WEST SUSSEX COUNTY COUNCIL CONSULTATION

TO:	Arun District Council FAO: Aishwarya Reddy
FROM:	Highways, WSCC
DATE:	15/04/2025
LOCATION:	9 Sea Drive, Ferring, BN12 5HD
SUBJECT:	FG/43/25/HH Ground and first floor front extensions, internal & external alterations including amendment to fenestrations and re-roofing. Erection of front wall and gates.
DATE OF SITE VISIT:	N/A
RECOMMENDATION:	Advice
S106 CONTRIBUTION TOTAL:	N/A

SITE BLOCK PLAN
1:500

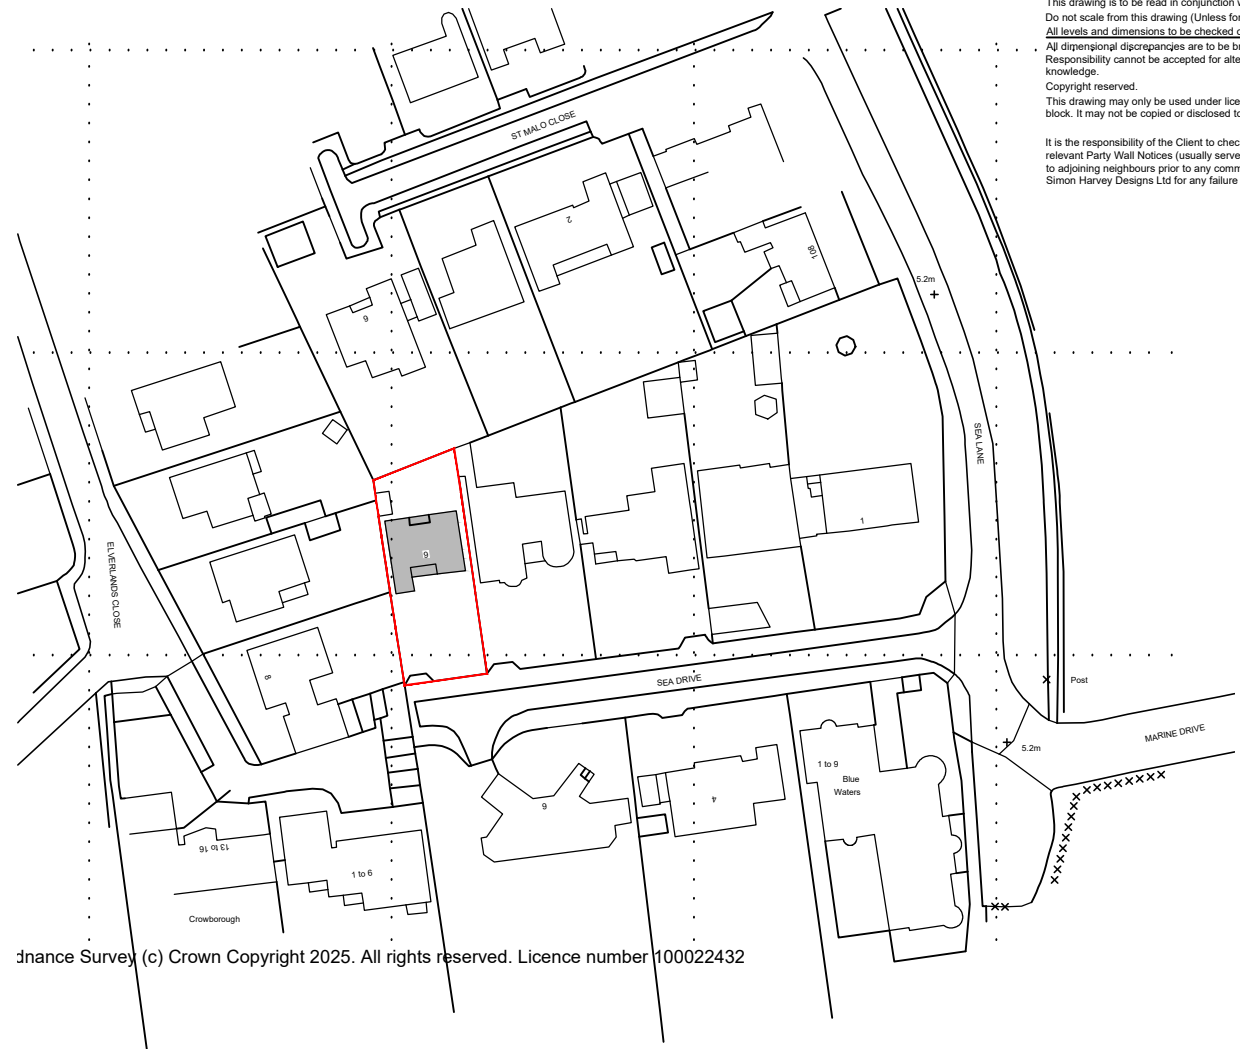
From inspection of the plans, the proposed works will provide enlarged living space for the existing dwelling, and this would not be anticipated to give rise to a material intensification of movements on the maintained highway network. Parking/turning arrangements appear unchanged.
